Online Comment

Application	H16-0487-16
Location	Former Network Rail Depot (on land to the North of Kings Road) Kings Road
Proposal	Application to discharge all conditions relating to application H16-0473-11

Name	Glen Chapman
Address	Environmental Services

Date Submitted	24-05-16
For/Against	Comments

AMENDED PLAN

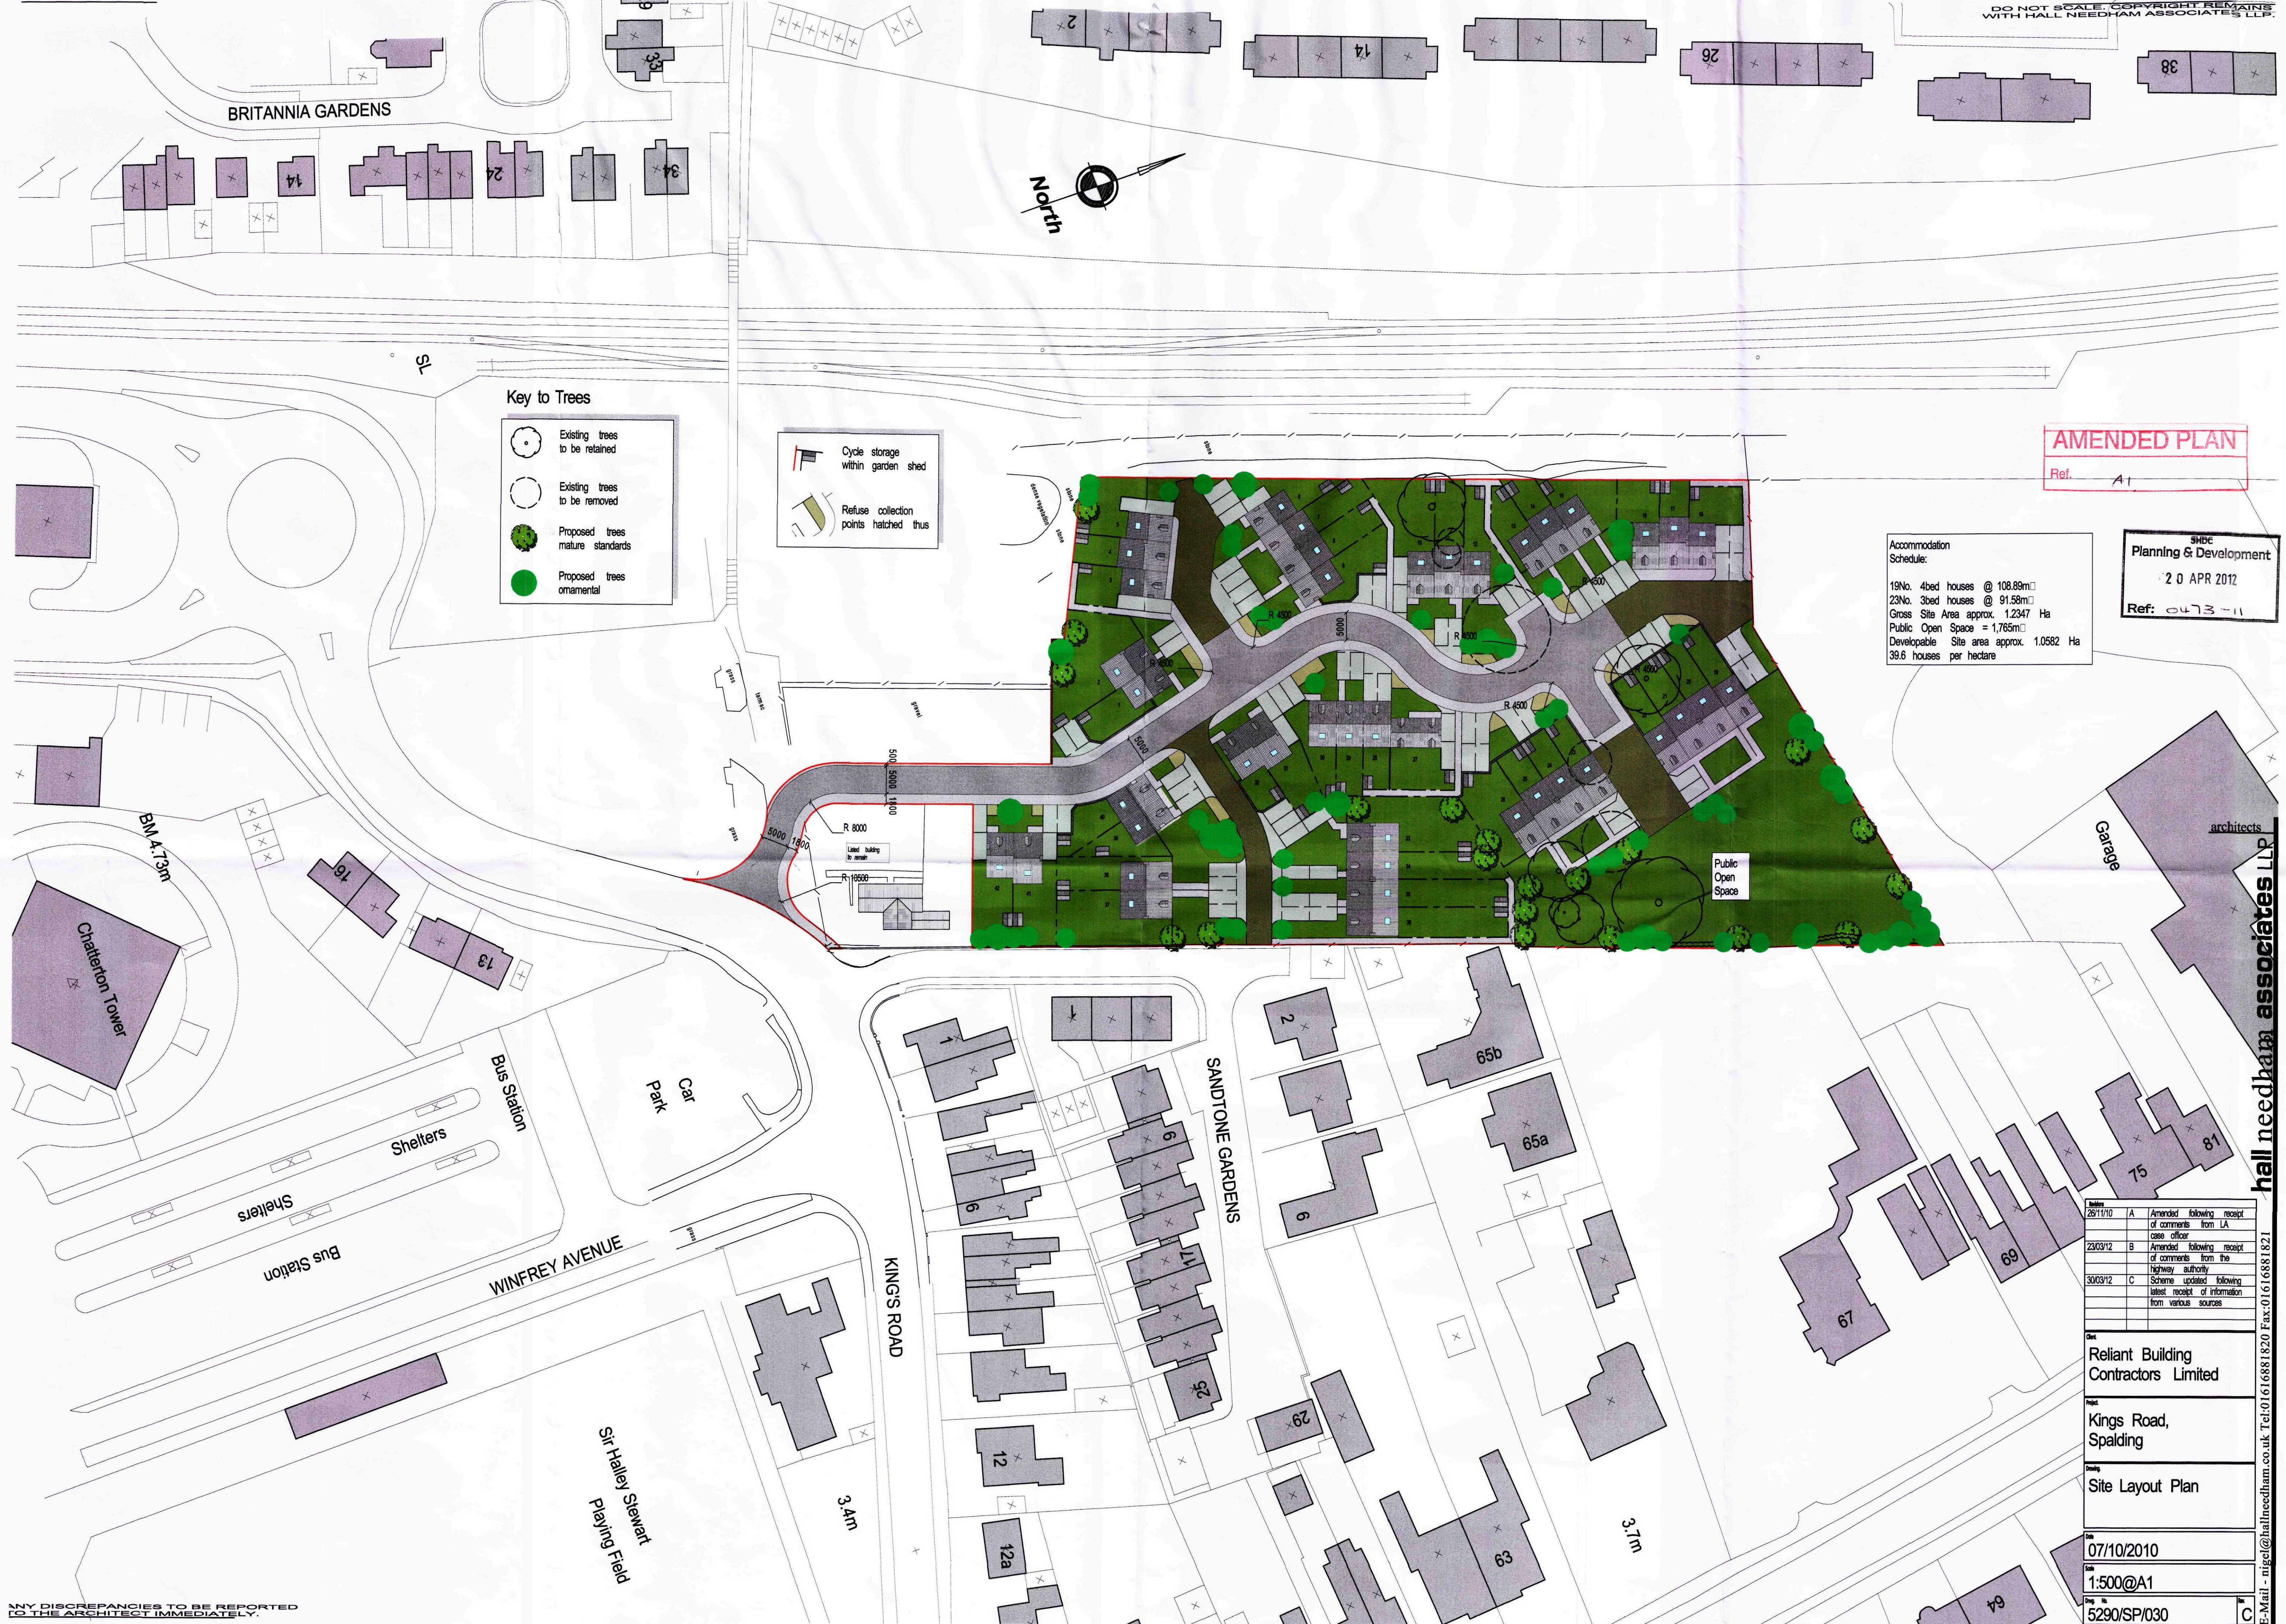
Access roadways to residential properties should be constructed to an adoptable standard under an agreement with Lincolnshire County Council so that they will become public highways. This will enable refuse/recycling collections to be carried out from outside individual properties without the need for communal collection points.

If not utilised correctly communal collection points become areas of dispute for residents of adjacent properties.

Should it be agreed that communal collection points will form part of this development the position of those collection points should be made clear to the potential occupiers of the properties nearby. This should not just be to the properties that will need to use the collection points but also the ones who will have them outside their properties.

The first access roadway on the right as you enter the site has a refuse collection point shown away from its junction with the main highway. If the access road is not to be adopted as public highway collections will not be made from this point.
